A1 in Northumberland: Morpeth to Ellingham

Scheme Number: TR010059

Applicant's Comments on Responses to ExA's First Written Questions

January 2021

**Appendix B Working Area around West Linkhall Scheduled  
Monument and North Charlton Scheduled Monument**

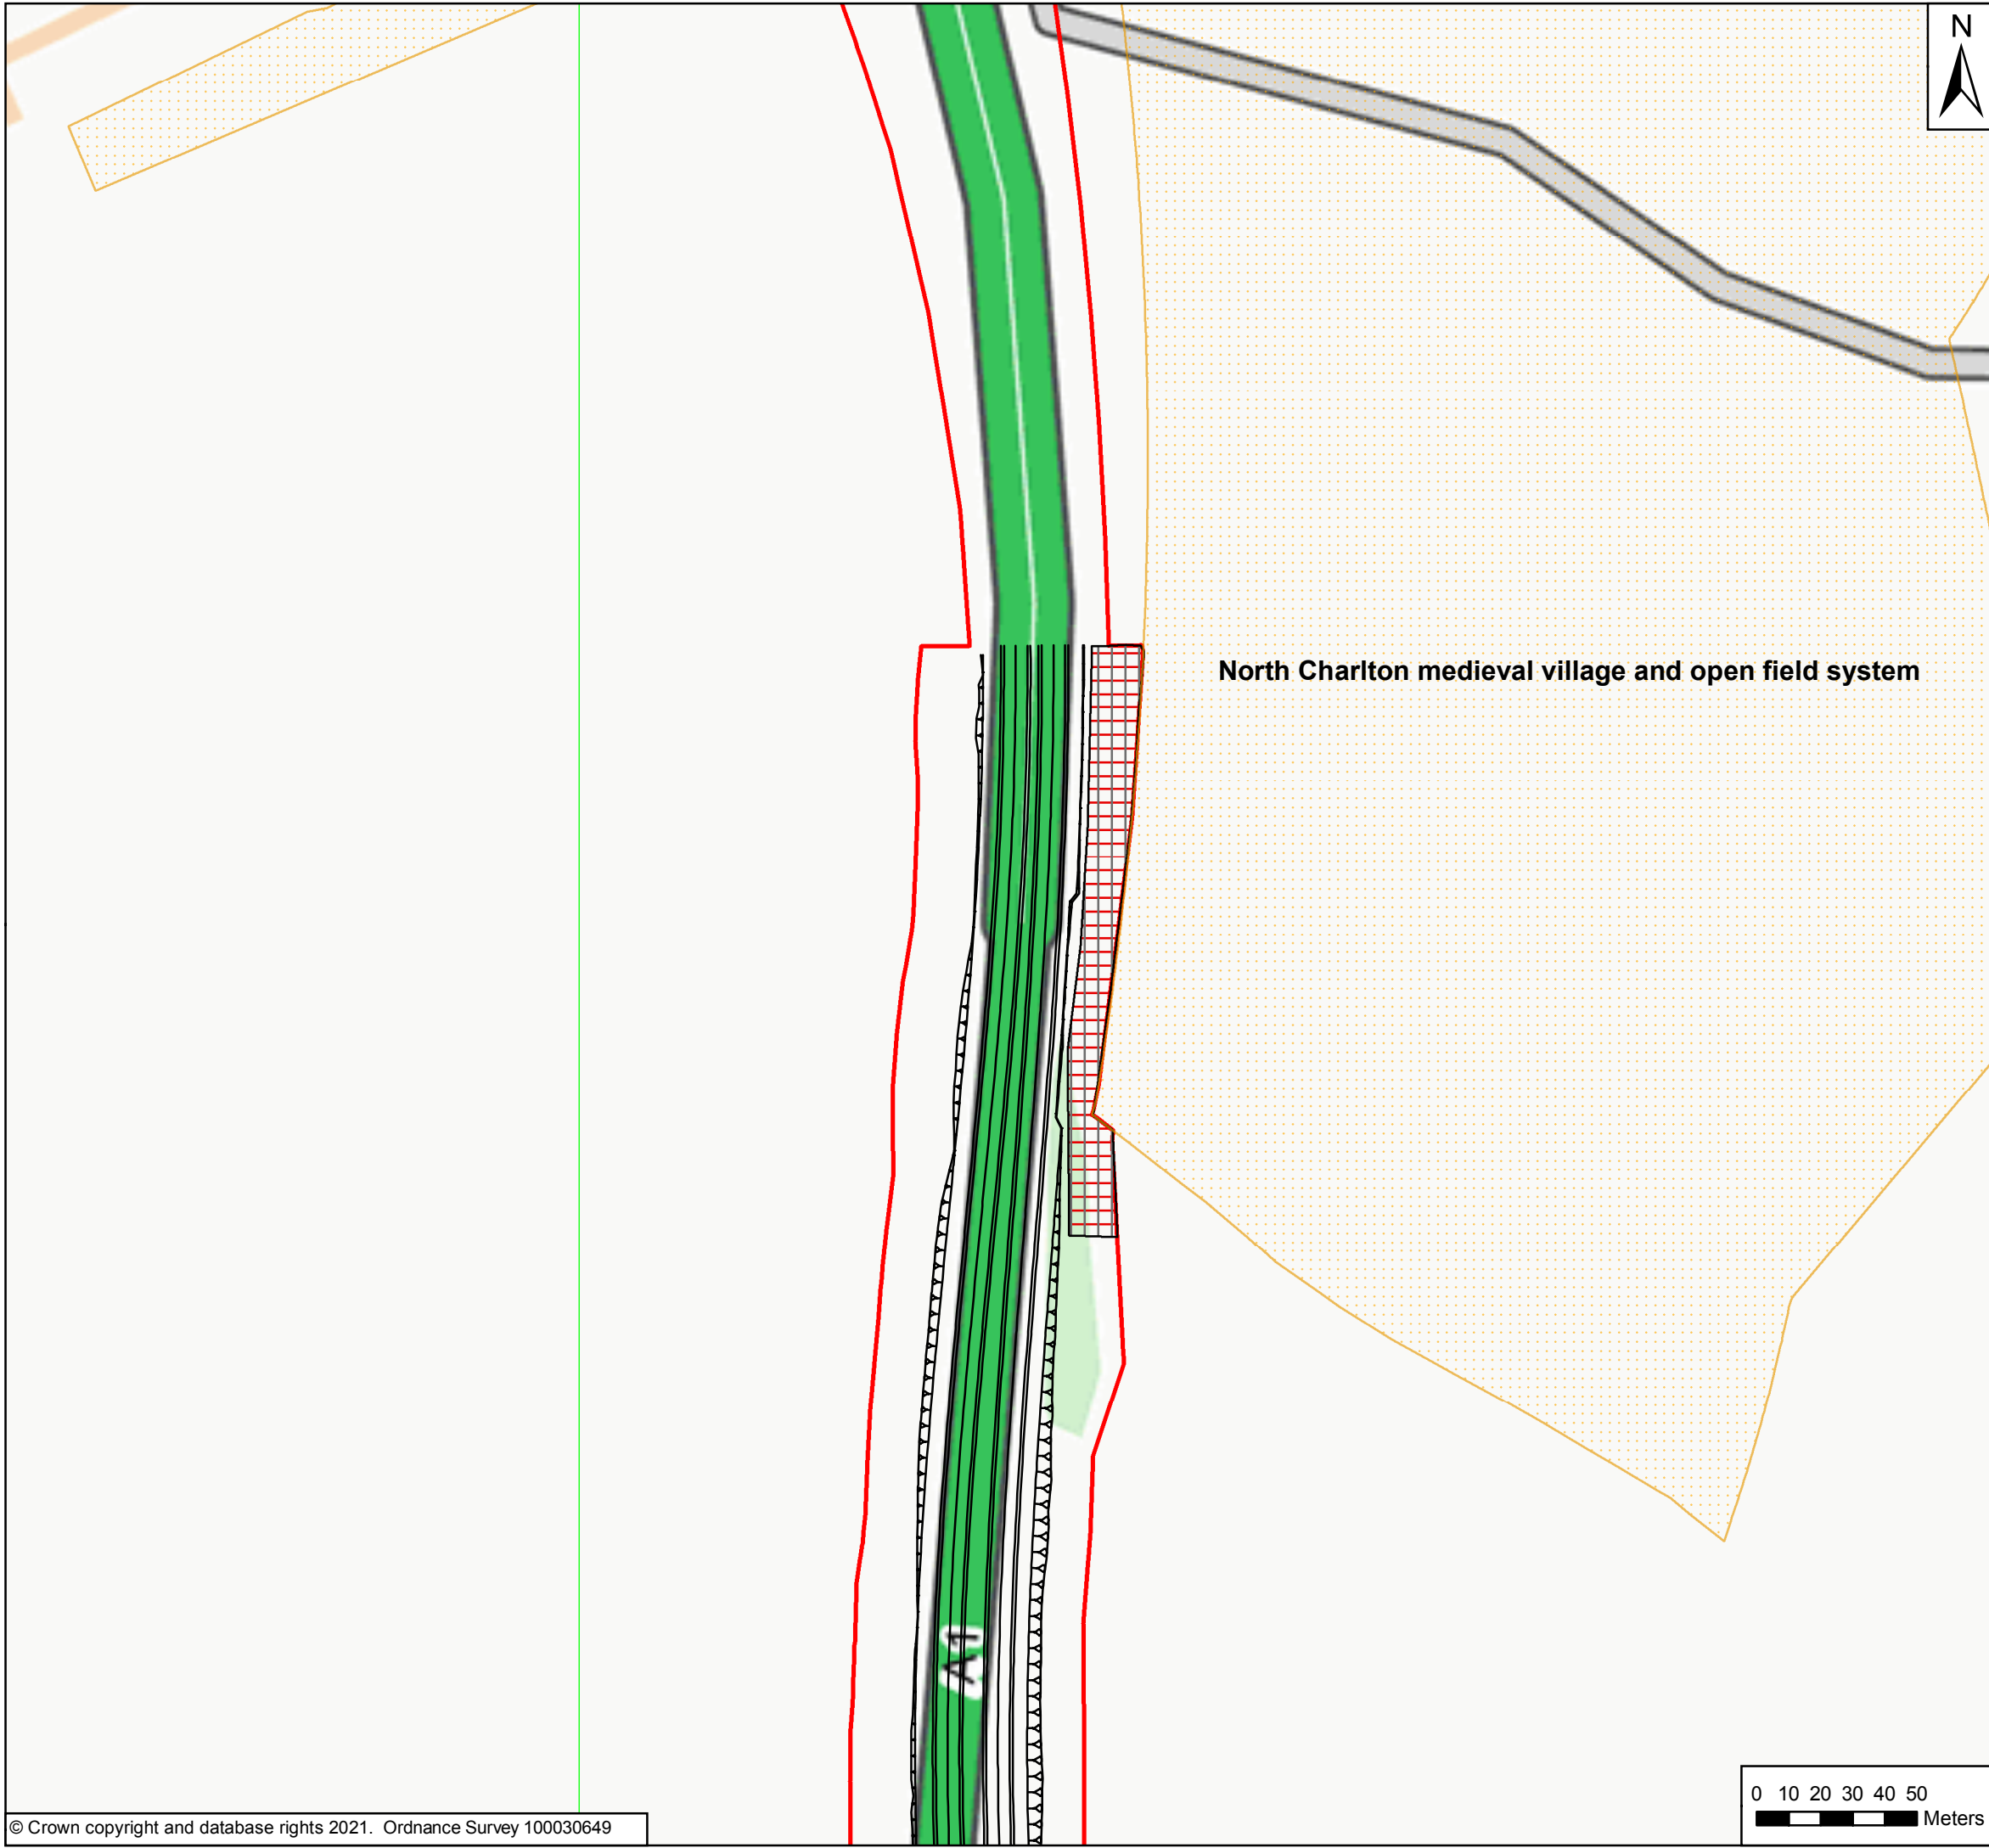
In pre-application discussions, and within the information supporting the current application, it seems clear that the intention is to avoid such impacts. This is welcomed.	1. Noted and agreed. See further responses below.
		However, the plans submitted do not show the boundary of the DCO and the boundary of the scheduled monuments on the same	1. Detailed plans showing the Order limits and the scheduled monuments of North Charlton medieval village and open field

Ref. No:	Question:	Historic England Response:	Applicant's Response:
		<p>plan, and at a sufficiently high scale to be able to confirm that this is indeed the case.</p> <p>This means that whilst we don't doubt the intention of avoiding the scheduled sites, at this point we cannot be definitive that physical impacts on scheduled monuments will be avoided. To resolve this, our suggestion is for the applicant to submit such a plan, showing the DCO boundary and scheduled monuments on the same high scale plan.</p> <p>This would then allow us to be definitive on the issue of direct physical impacts, or to allow further discussion if the DCO clips or otherwise impacts on any scheduled sites.</p>	<p>system and the Camp at West Linkhall accompanied the Applicant's response to Historic England's Relevant Representation submitted at Deadline 1 [REP1-070]. These plans confirmed that no land within the Scheduled Monuments is within the Order limits and show an exclusion zone where the Order Limits directly abut the boundary of the North Charlton Scheduled Monument.</p> <p>2. As such, it can be concluded with confidence that there would not be direct physical impacts on these scheduled monuments.</p>
